# Rezoning Transportation Analysis

Petition Number: Insert Zoning Petition #2021-036

General Location Identifier: Tax ID 06306125

| Date     | Description        |
|----------|--------------------|
| 05-27-21 | Second Review (EL) |

RZ-1

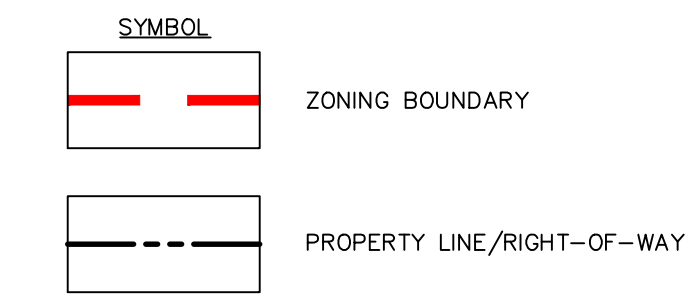
3. **Update to comment (site plan dated 05.17.21):** meander the sidewalk to preserve existing trees. Sidewalk may be contained within a sidewalk utility easement 2-feet from proposed back of sidewalk, where located outside of the public right-of-way. Revise the site plan and conditional note(s) to commit to construct an 8-foot planting strip and 6-foot sidewalk on South Hoskins Road, labeled and dimensioned from the road centerline and future curb line location, in support of the Charlotte WALKS Council-adopted policy. Replace the existing accessible ramp at the intersection with two standard CLDSM PROWAG directional ramps.
